M54 to M6 Link Road TR010054

8.8 LIU(E) Draft Statement of Common Ground with Mark Commins & Tracey Commins

**8.8 LIU(E) Draft Statement of Common Ground with
Mark Commins & Tracey Commins**

STATEMENT OF COMMON GROUND

FIGURE 11.4
SHORT TERM CHANGE IN
TRAFFIC NOISE LEVELS
(DM2024 TO DS2024)

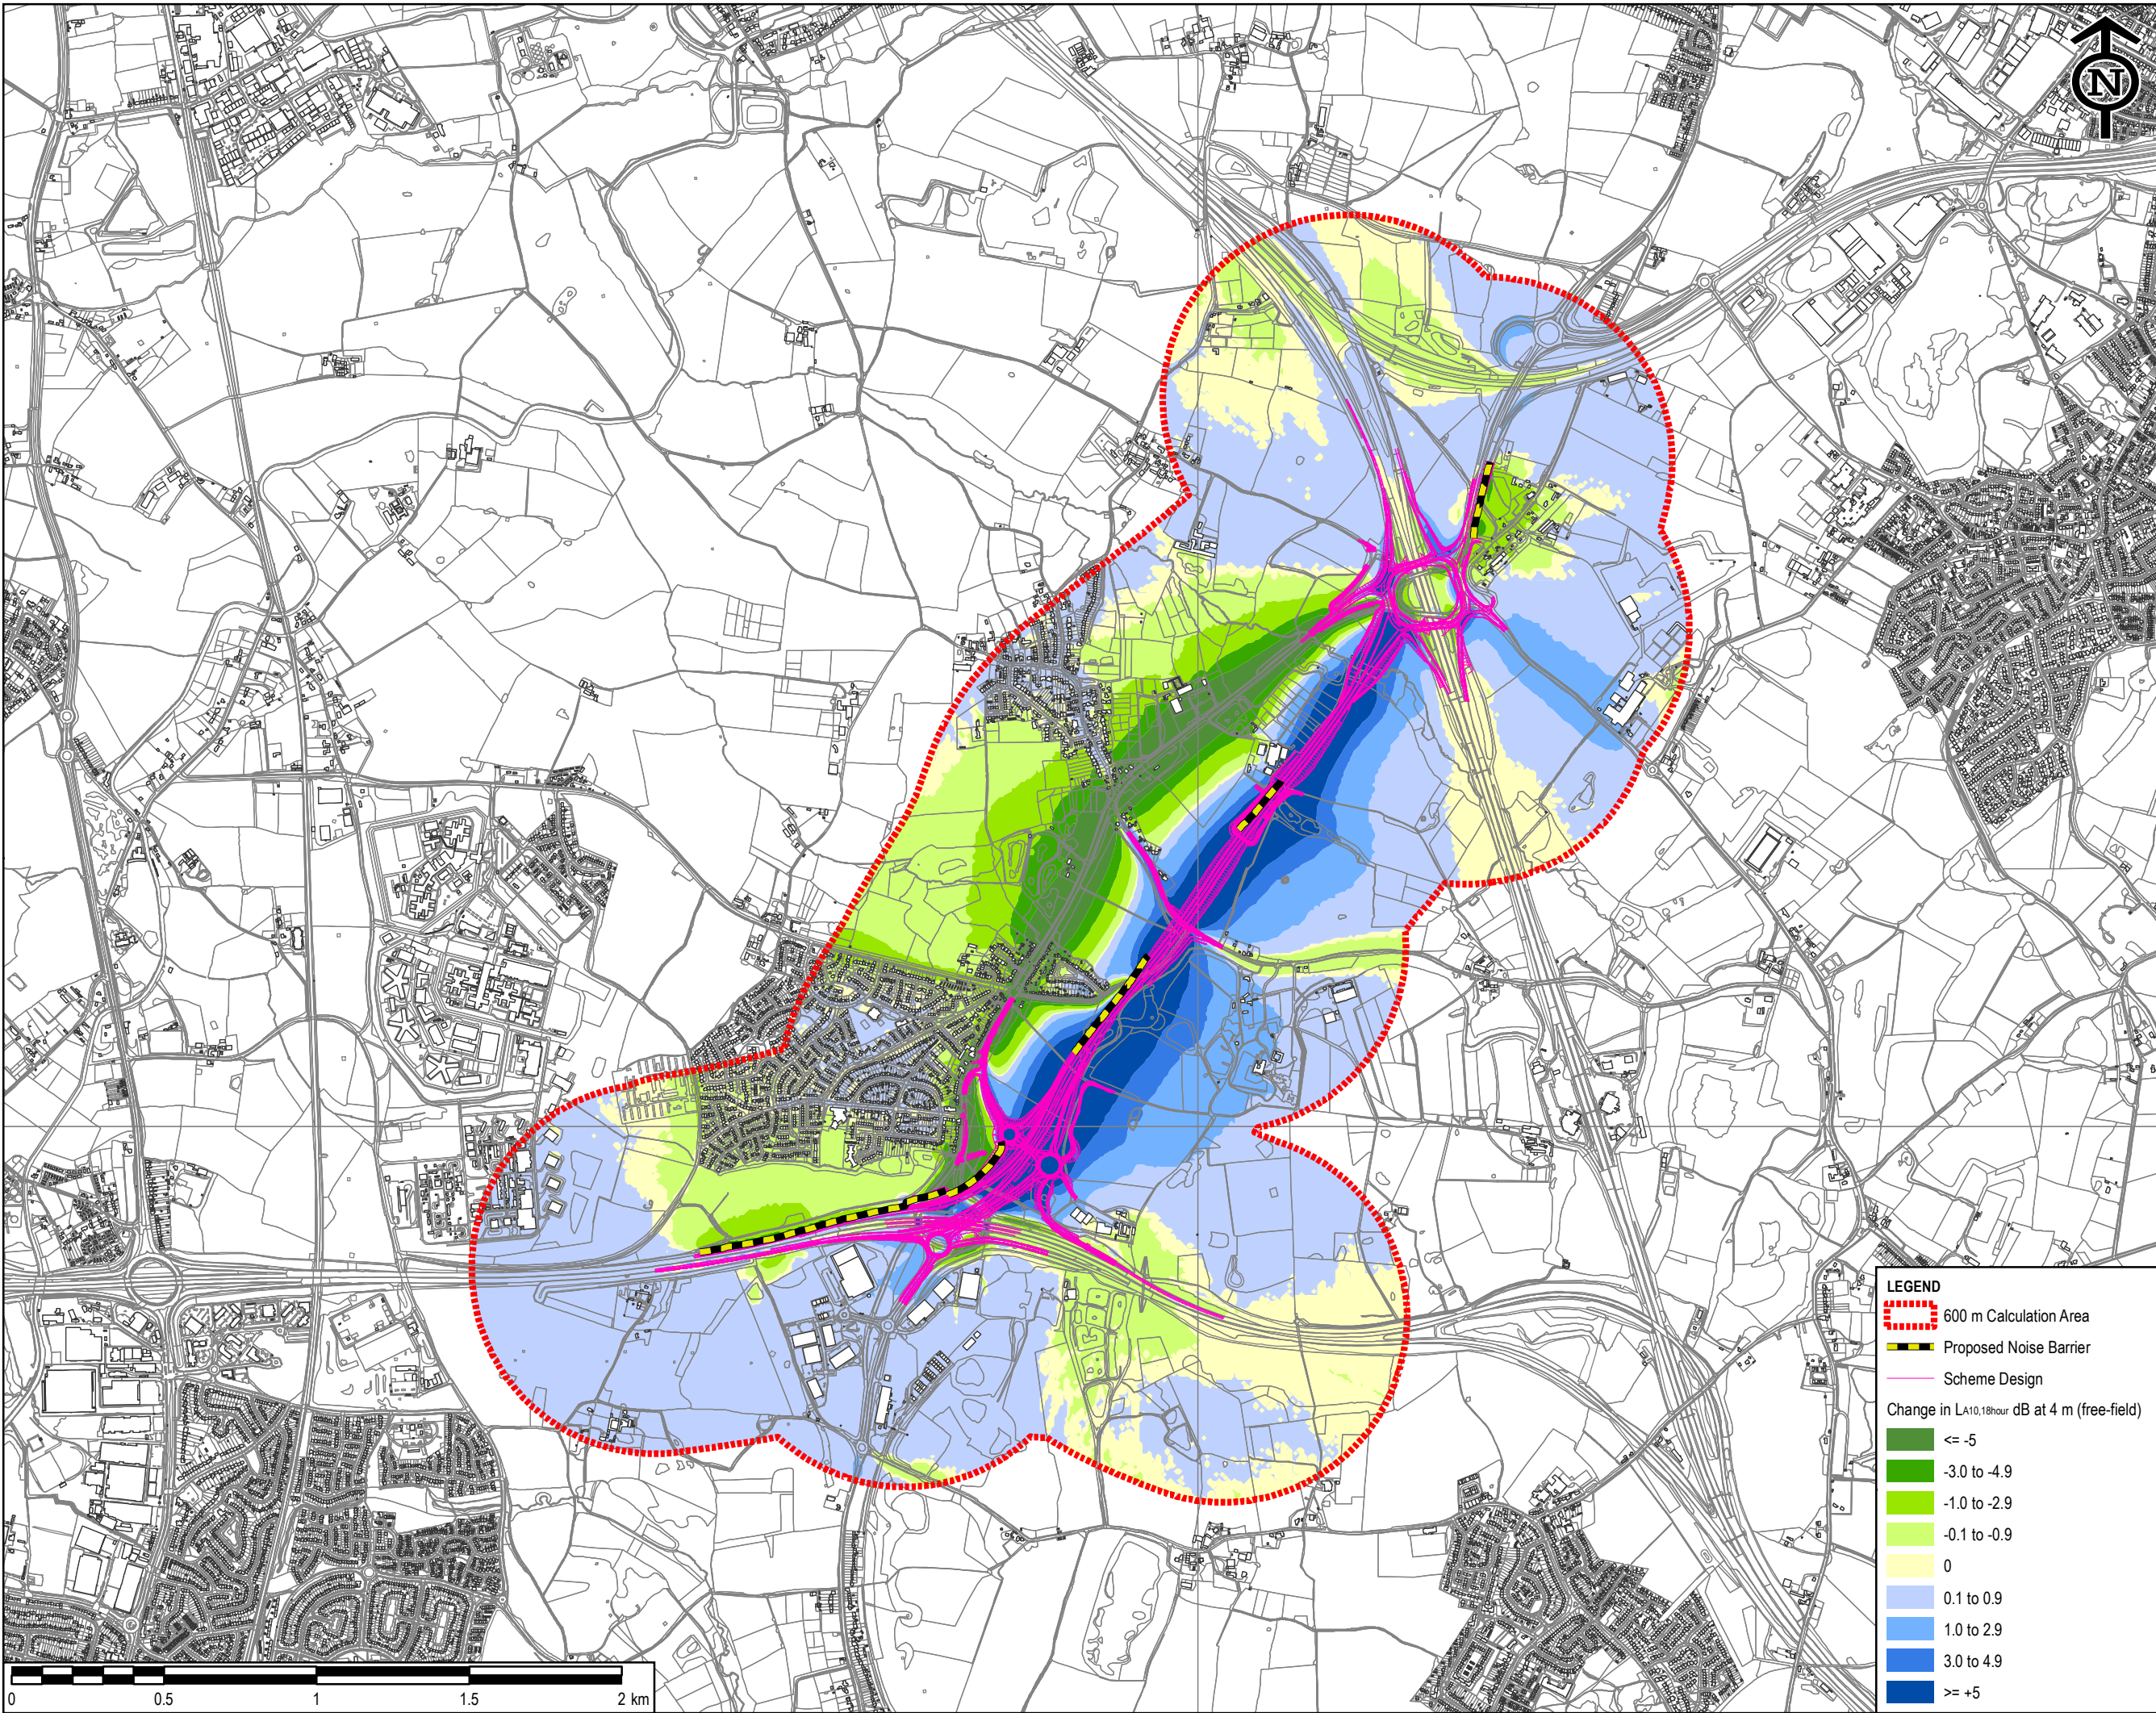
Issue	Landowner comment	Highways England Response	Status	Agreement likely (app) ¹	Agreement likely (IP)
		boundary and the back of the existing track. Consequently, the existing access track will be unaffected by the works and can continue to be used as per the current scenario. Highways England will continue discussions with the Landowner to ensure this remains the case.			
Proximity between highway realignment and fishing pool	Concern regarding the 3 metre proximity between the realigned A460 and fishing pool and the potential adverse impact on mental health and relaxation of Brookfield Farm customers	<p>The A460 will only be realigned to the North-East of the watercourse that crosses the A460. As this watercourse runs to the north of the fishing pool there would be no realignment of the carriageway in the vicinity of the pools.</p> <p>The 3 metre proximity referred to in the above response is in relation to the edge of land take required to the track, not from the highway boundary.</p> <p>Historically a strip of land was required alongside the ponds to allow for any changes in earthworks, however, Highways England is seeking to minimise works in this area as part of detailed design. Flexibility is required in the DCO to ensure the Scheme is deliverable so no changes can be made to the Scheme as presented at this stage.</p> <p>Figure 11.4 of the Environmental Statement [AS-098/6.2] illustrates the anticipated change in traffic noise levels due to the</p>	Under discussion	High

Issue	Landowner comment	Highways England Response	Status	Agreement likely (app) ¹	Agreement likely (IP)
		operation of the Scheme in the opening year (2024). This illustrates how the change varies across the fishing pond from a reduction in traffic noise levels of around 5 to 7 dB (LA10,18h) at the western side of the fishing pond adjacent to the existing A460, which undergoes a large reduction in the volume of traffic, to an increase in traffic noise of around 4-7 dB (LA10,18h) on the eastern side of the fishing pond adjacent to the new link road. Therefore, the impact of the Scheme varies from beneficial to adverse across the fishing pond, with the magnitude of the increases and decreases being fairly comparable.			
Position of new balancing ponds, outfall locations and water quality	Query the quality of water discharged into the watercourse and water treatment system for adjoining balancing pond including the location requirements for the proposed balancing pond	<p>Measures will be included in the design to ensure that the discharge water quality meets the required standard set out in the Water Framework Directive; this includes features such as Penstock Valves to protect downstream water bodies in the event of a spillage.</p> <p>The pond has been located to the west of the link road due to the direction of flows (to the west). The balancing pond is located at</p>	Under discussion	Medium

Drawing Title
**FIGURE 11.1
 NOISE LOCATION PLAN**

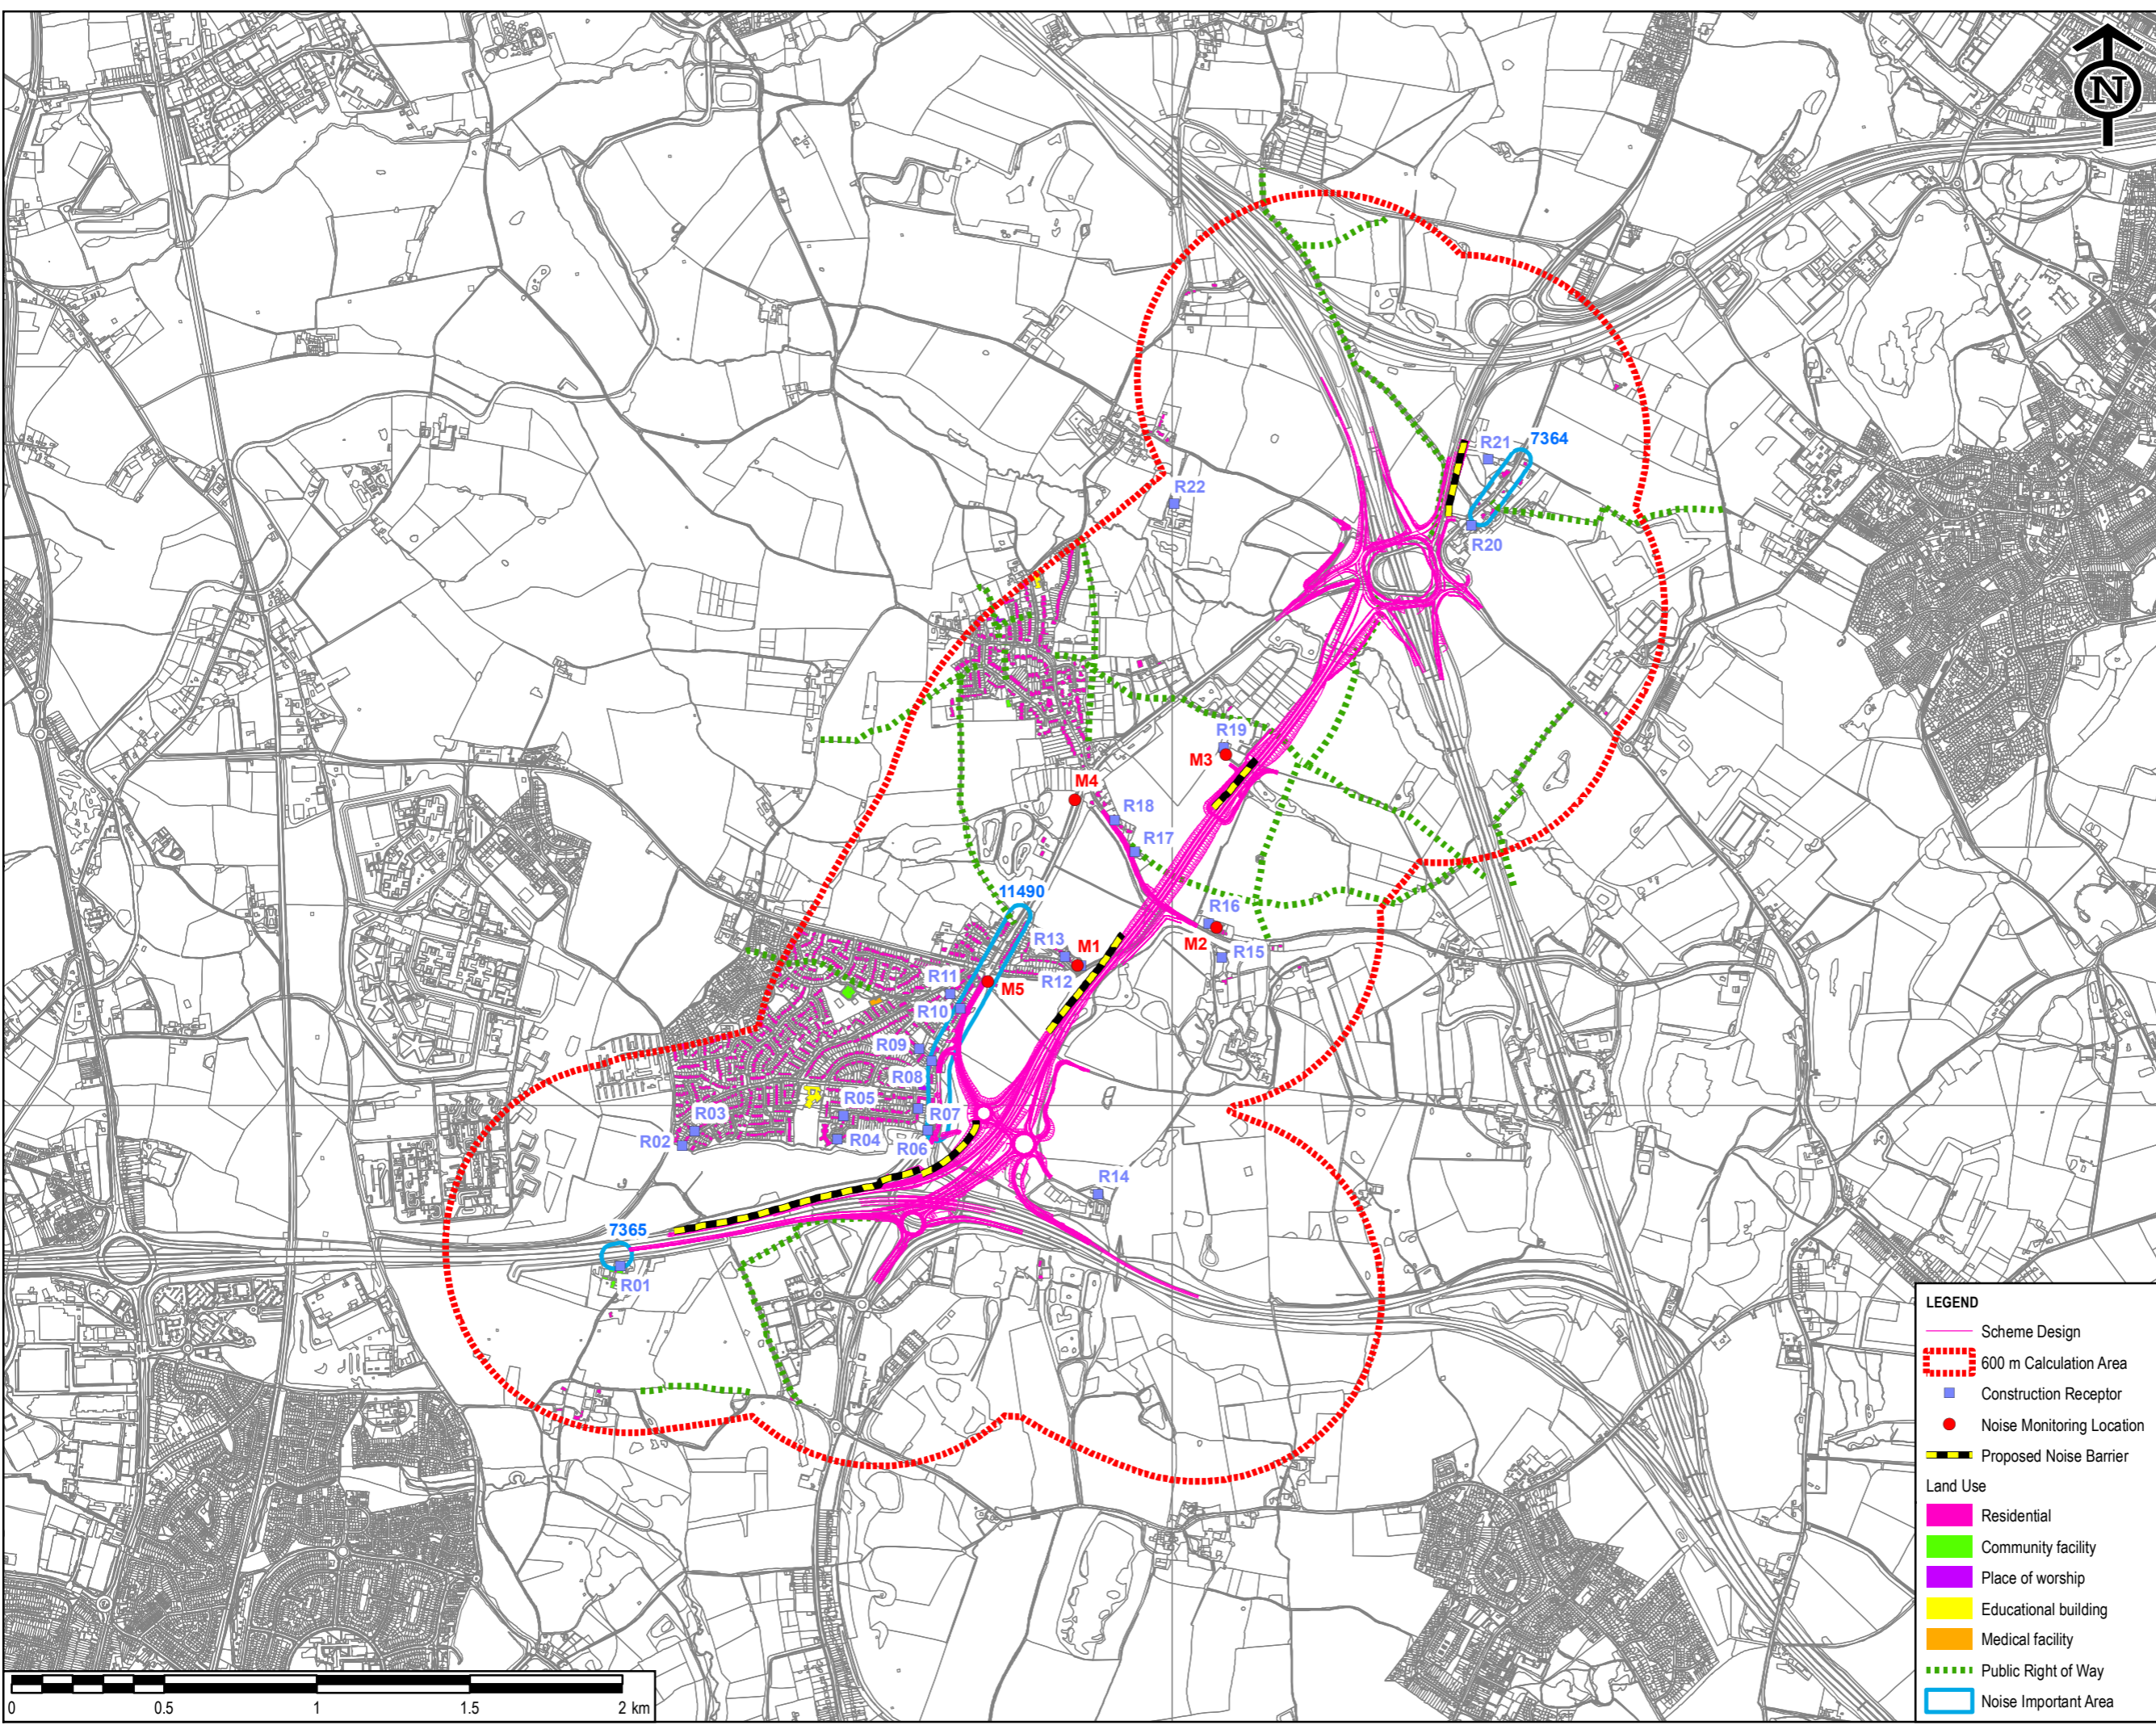
Noise monitoring	Question raised why noise monitoring surveys were not conducted from the club house	Noise monitoring has been undertaken as part of the Environmental Impact Assessment and the results are reported in Figure 11.1 of the Environmental Statement [TR010054/APP/6.2]. The noise monitoring is used to develop an understanding of the general noise climate in the vicinity of the Scheme, and as part of a validation exercise for the prediction model; it is not	Agreed (To be confirmed by landowners)	High

Issue	Landowner comment	Highways England Response	Status	Agreement likely (app) ¹	Agreement likely (IP)
		used to establish baseline conditions for individual receptors. The traffic noise levels and any subsequent change in the traffic noise levels as a result of the Scheme are then predicted using the model. In order to quantify traffic noise, Highways England would normally want to avoid siting monitoring equipment near specific known noise sources which might distort the numeric results (e.g. a building which may generate entertainment noise).			
Air quality impacts	Air quality assessment at Brookfield Farm	Based on the affected road network, sufficient monitoring data is available from Highways England and local authority sources to confirm the model performance, without the need for further monitoring at this stage of the design. The assessment on air quality in Chapter 5 of the Environmental Statement [TR010054/APP/6.1] demonstrates that no properties will experience air pollution levels above national air quality objective values post construction as a result of the Scheme. The significant reduction in traffic along the A460 will potentially enable future improvements to the road for pedestrians and cyclists, improve the environment around the road and may contribute positively to the identity of these villages along the route.	Agreed (To be confirmed by landowners)	High
